**OXFORDSHIRE COUNTY COUNCIL'S RESPONSE TO CONSULTATION ON THE
FOLLOWING DEVELOPMENT PROPOSAL**

Application no: 13/01056/OUT

Proposal: OUTLINE - Up to 200 residential units, access, amenity space and associated works

Location: South Lodge Fringford Road Caversfield Bicester OX27 8TH

**Existing Junction Arrangement**

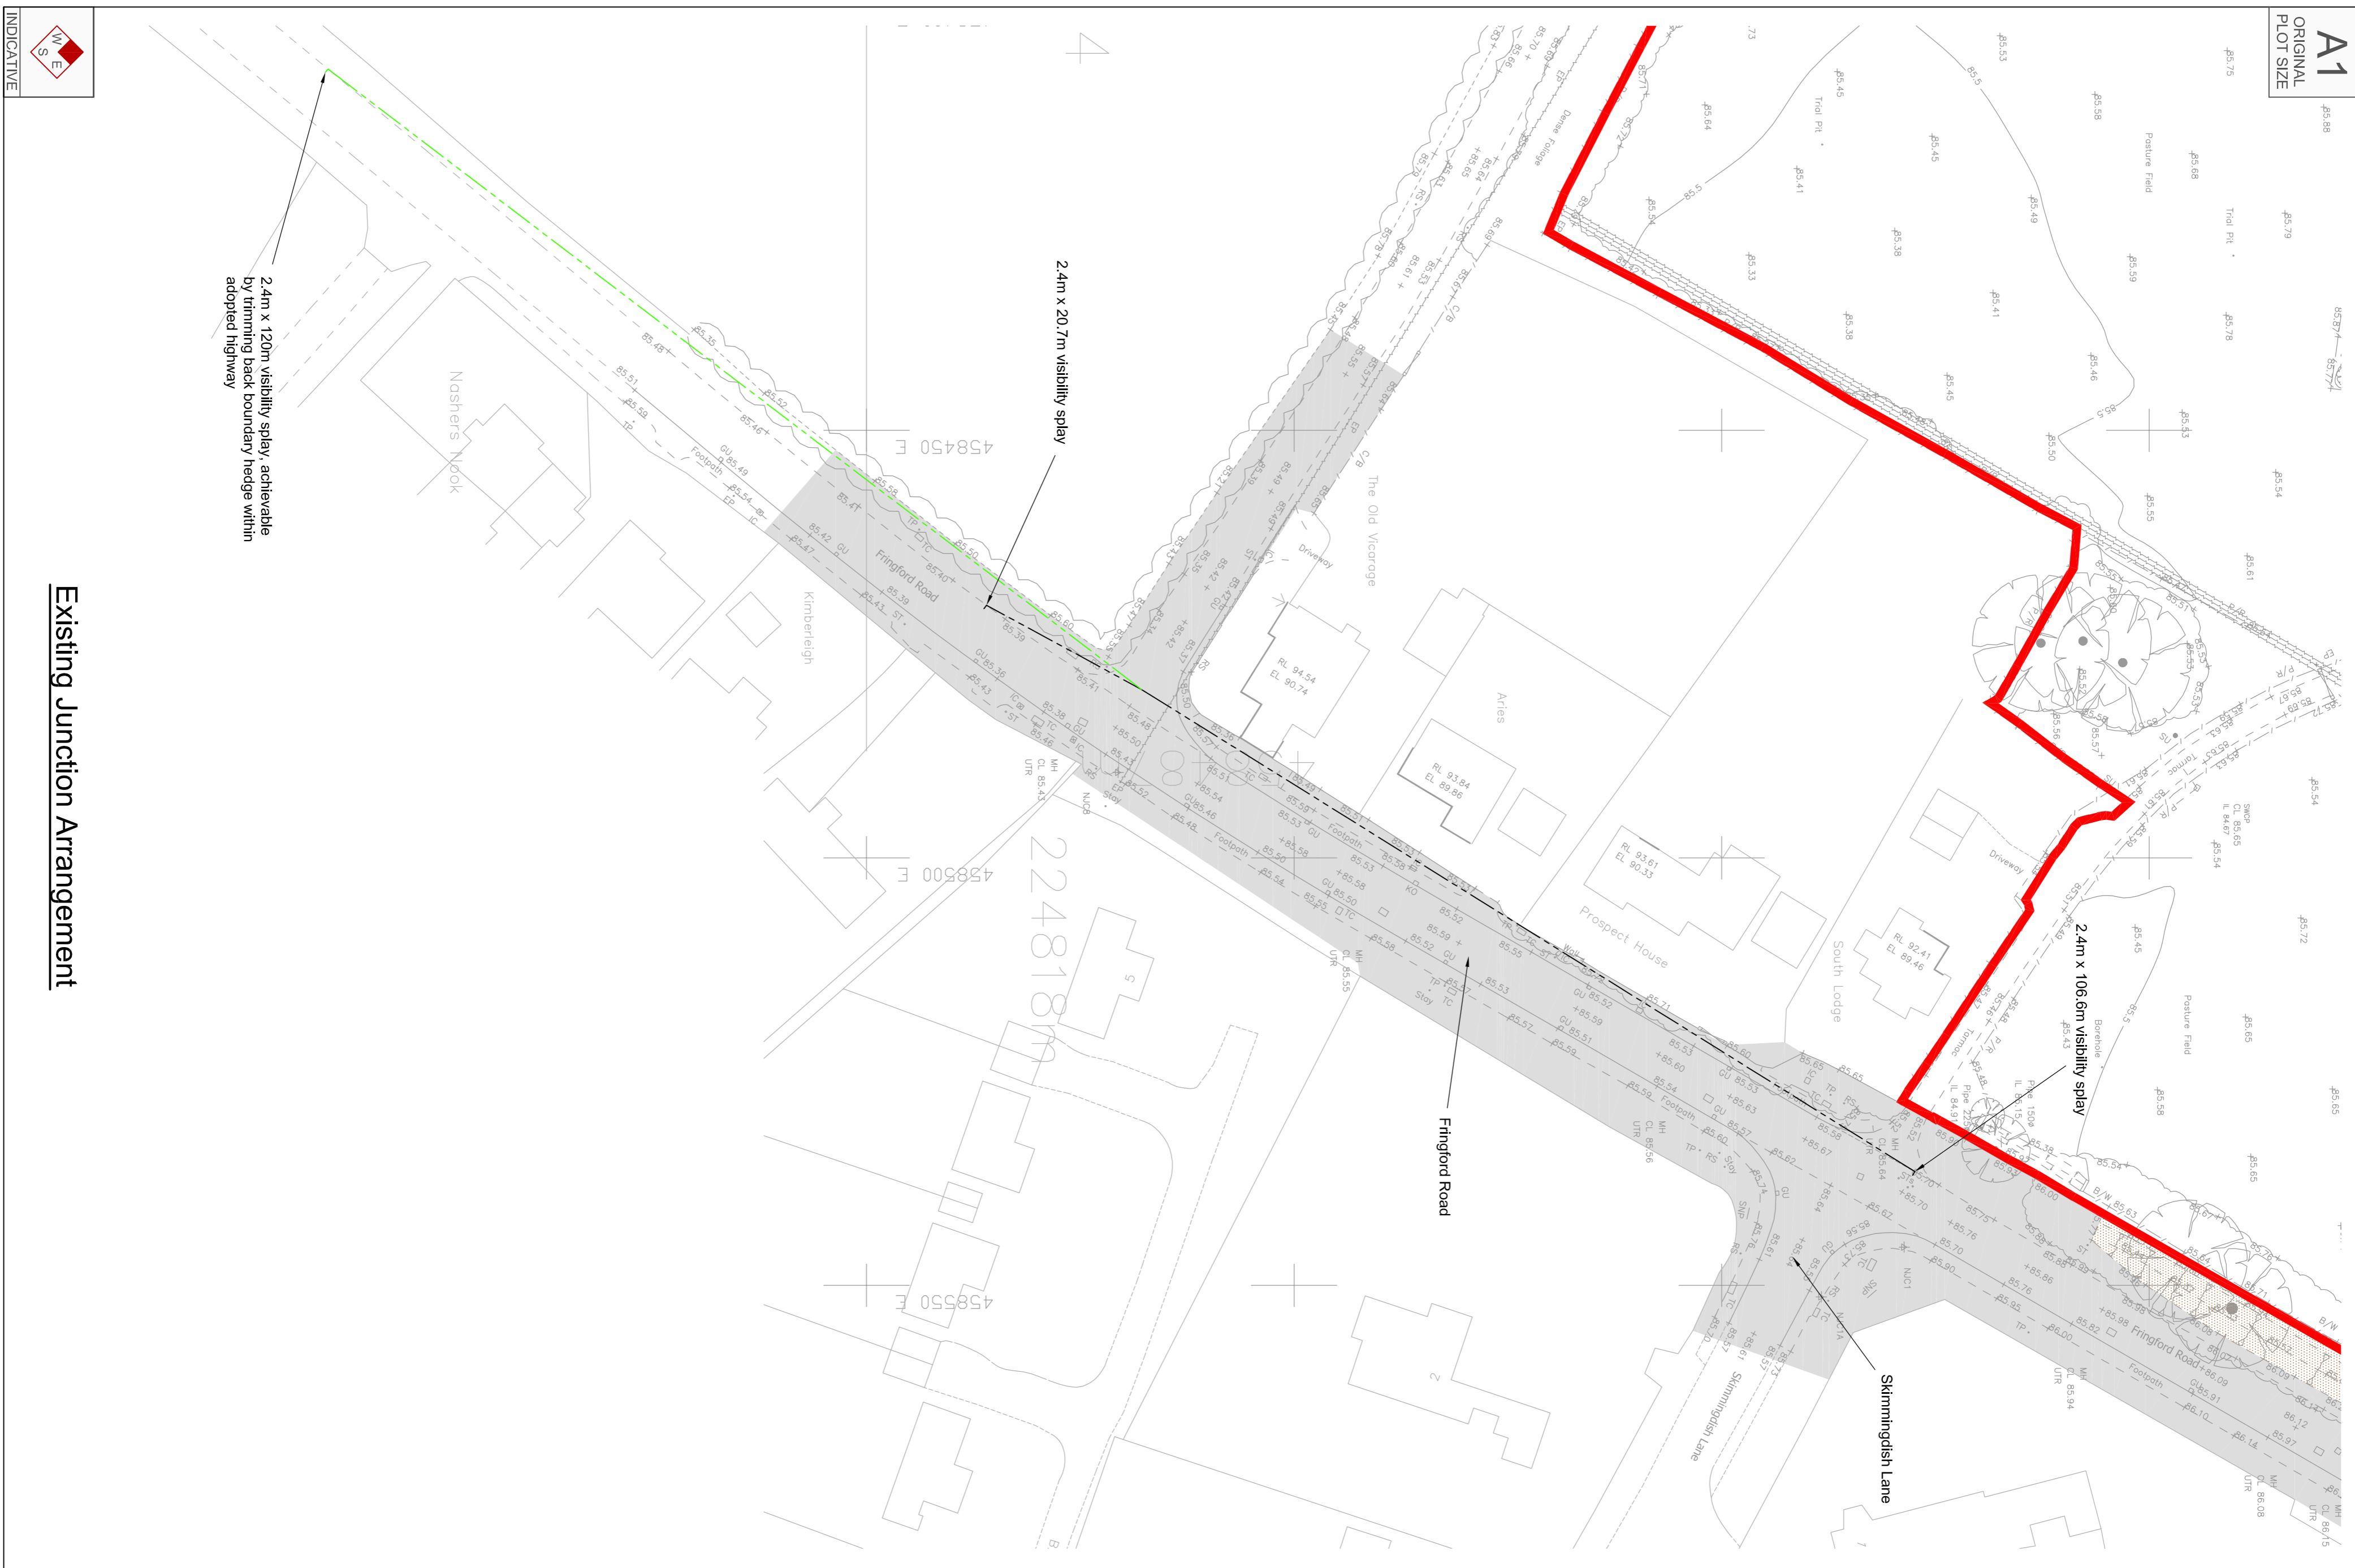
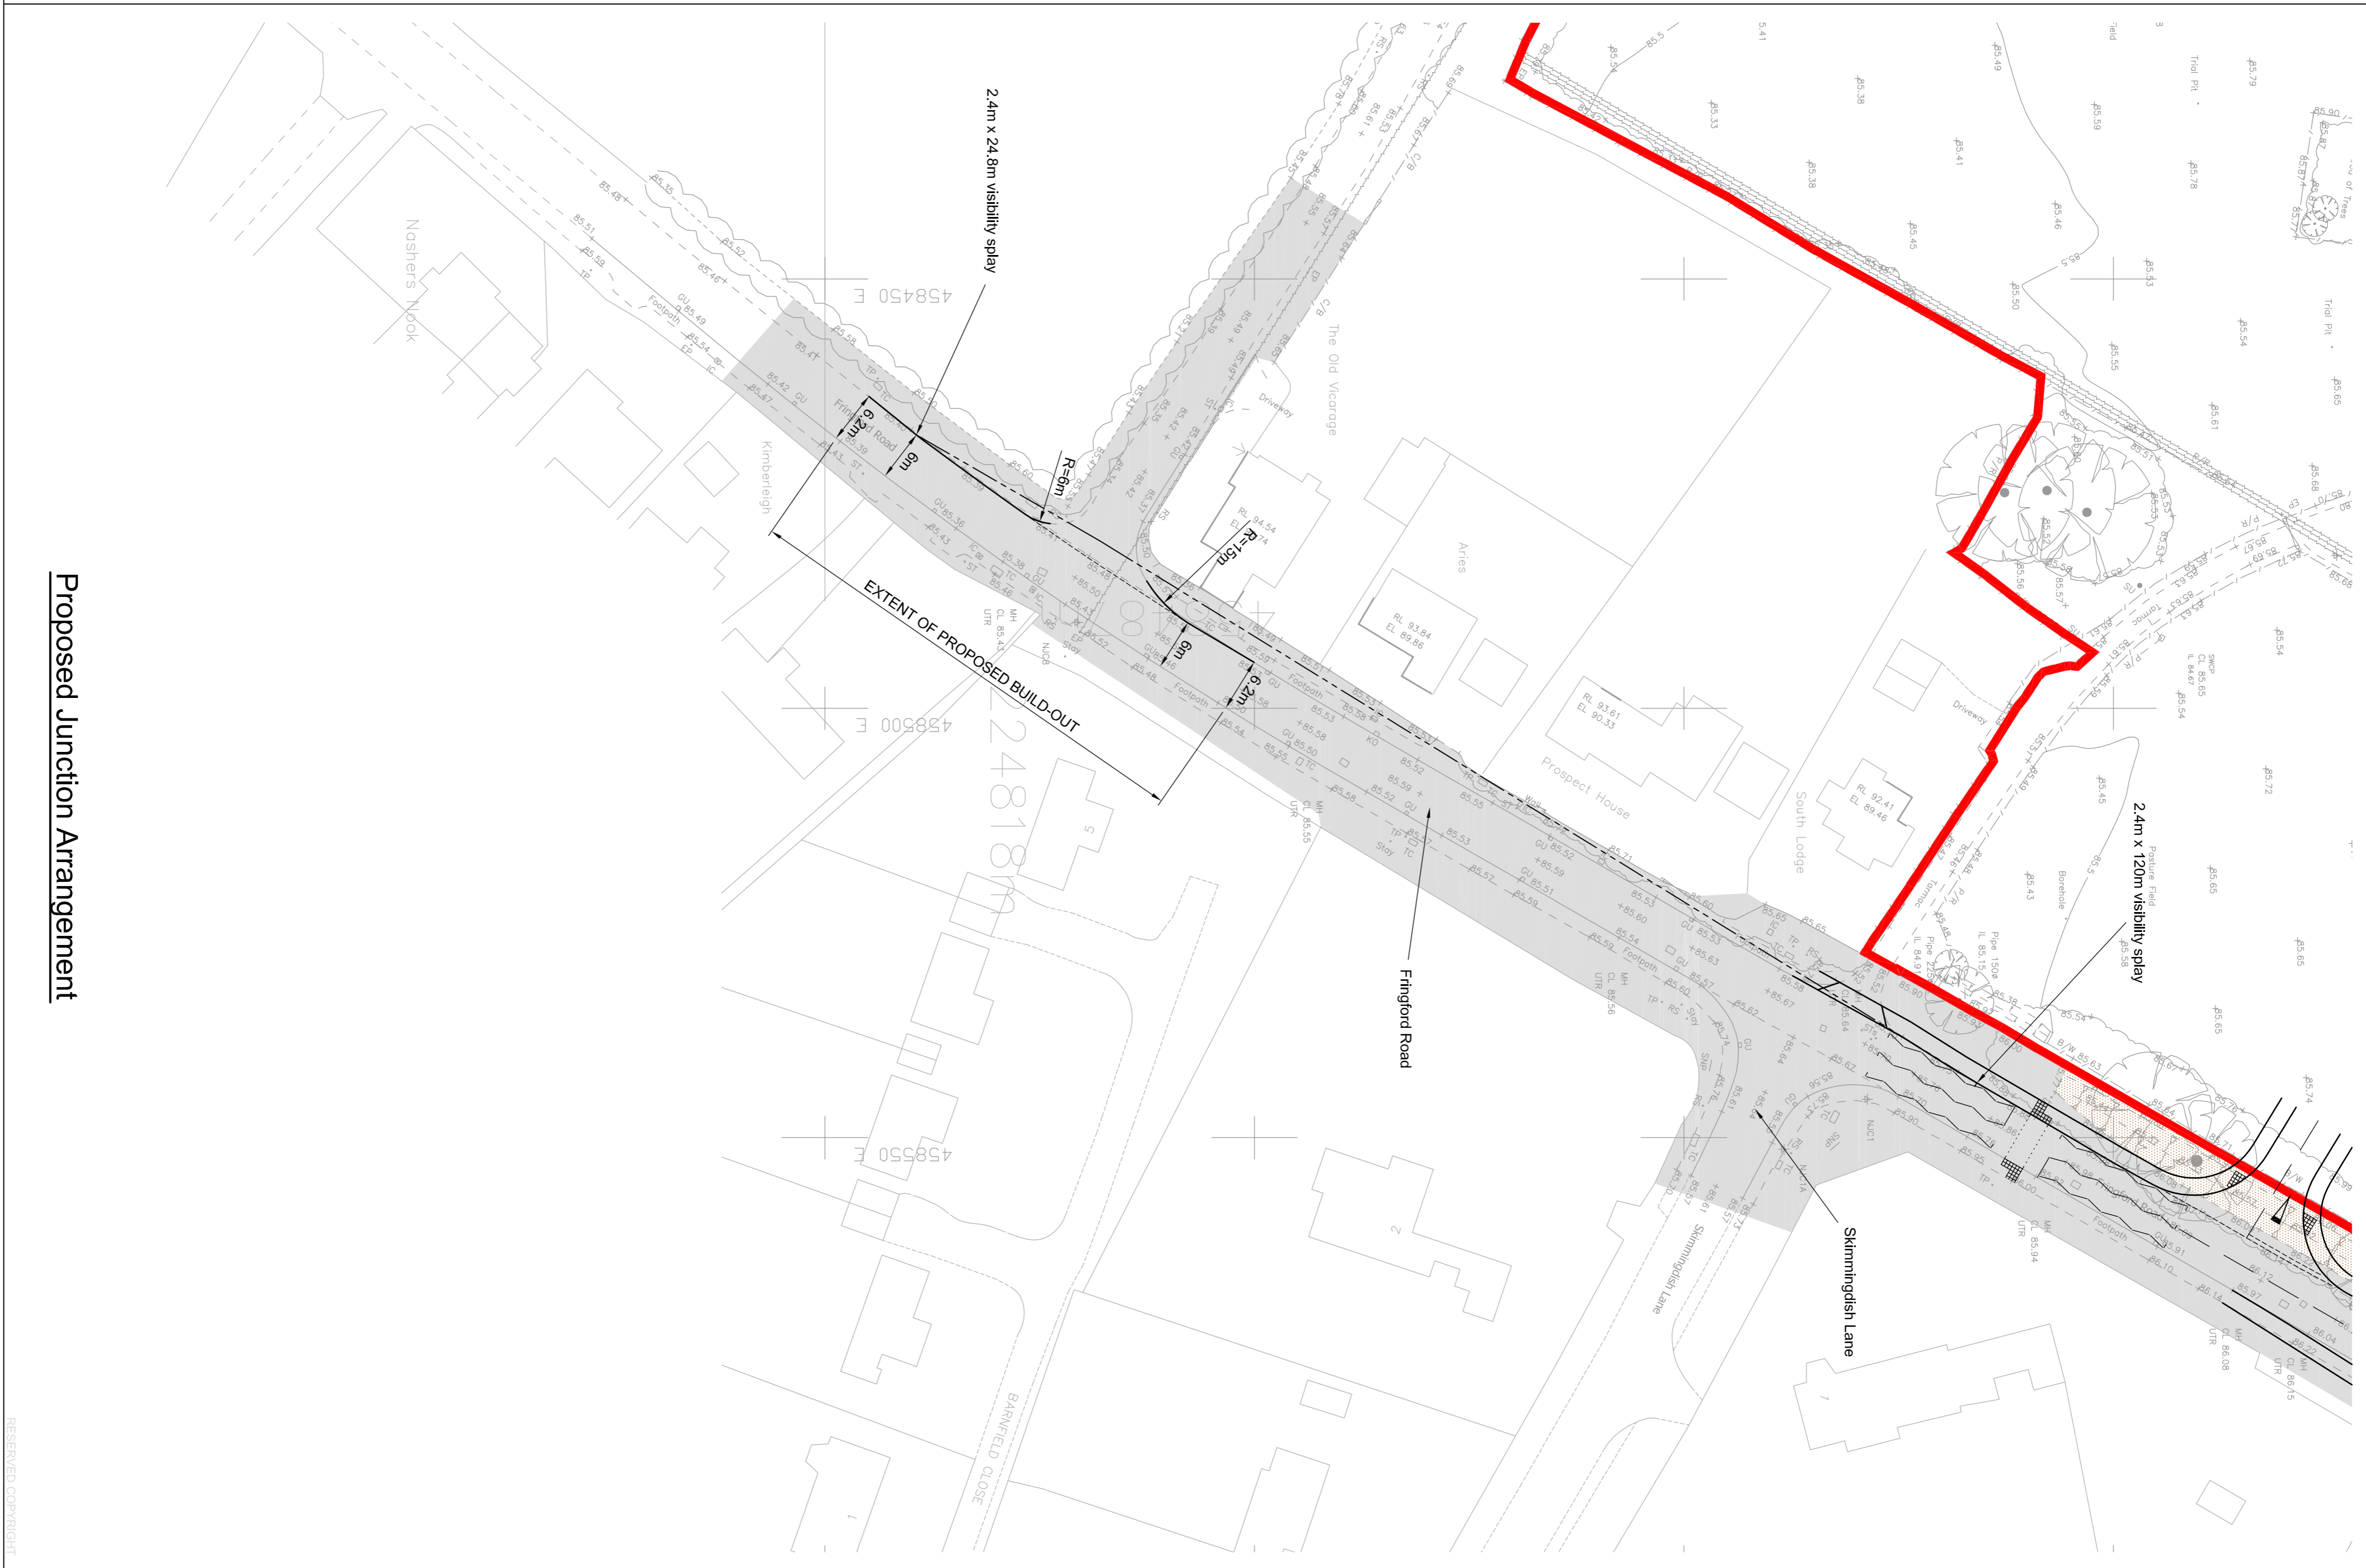
The application proposes a new vehicular access onto Fringford Road. The detail of this proposed access, including visibility splays, has not been submitted for consideration and approval. Vision splays of 2.4m x 120m will be required, provided that the 85th percentile speed of traffic in the vicinity is 40mph in line with the local speed limit. Such a vision splay would extend past the applicant's red-line application boundary, and would likely necessitate the removal of third party trees and vegetation to the north of the site. It has not been demonstrated that a safe, adequate access to the public highway can be achieved. **(Concern – highway safety)**

I note from site visit that the visibility from the unnamed road to the south onto Fringford Road is substandard. Given that the proposal is likely to intensify vehicular use of the unnamed road, this is a concern. **(Concern – visibility at unnamed road/ Fringford Road junction)**
